Network Rail Consultation Response

FAO:	Jillian Rann
Date:	16/09/2025
Application reference:	2025/91184
Proposal:	Erection of two storey industrial unit (Use Class E(g)(iii)), with associated car park, service area and other associated works
Location:	land off, Bretton Street, Savile Town, Dewsbury, WF12 9BZ

| TITLE | Drainage Strategy | | | | |

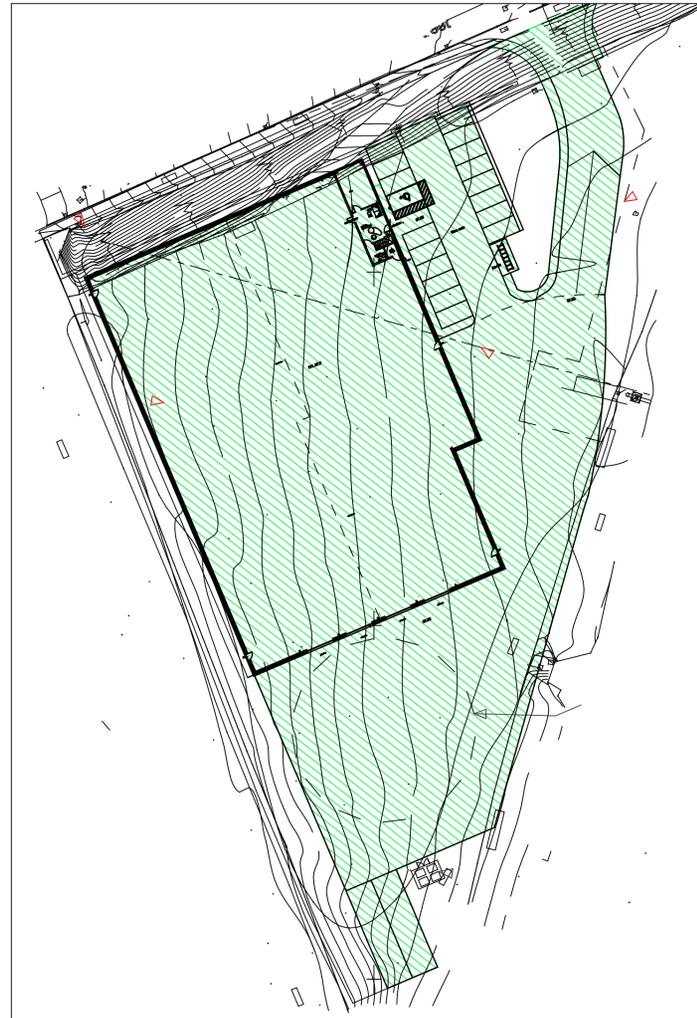
It is imperative that drainage associated with the site does not impact on or cause damage to adjacent railway assets. We note that the proposed works include the diversion of a Yorkshire Water sewer, which must be carefully managed in coordination with Network Rail's Asset Protection Team. This engagement is critical to ensuring that the stability of the nearby railway embankment is not compromised.
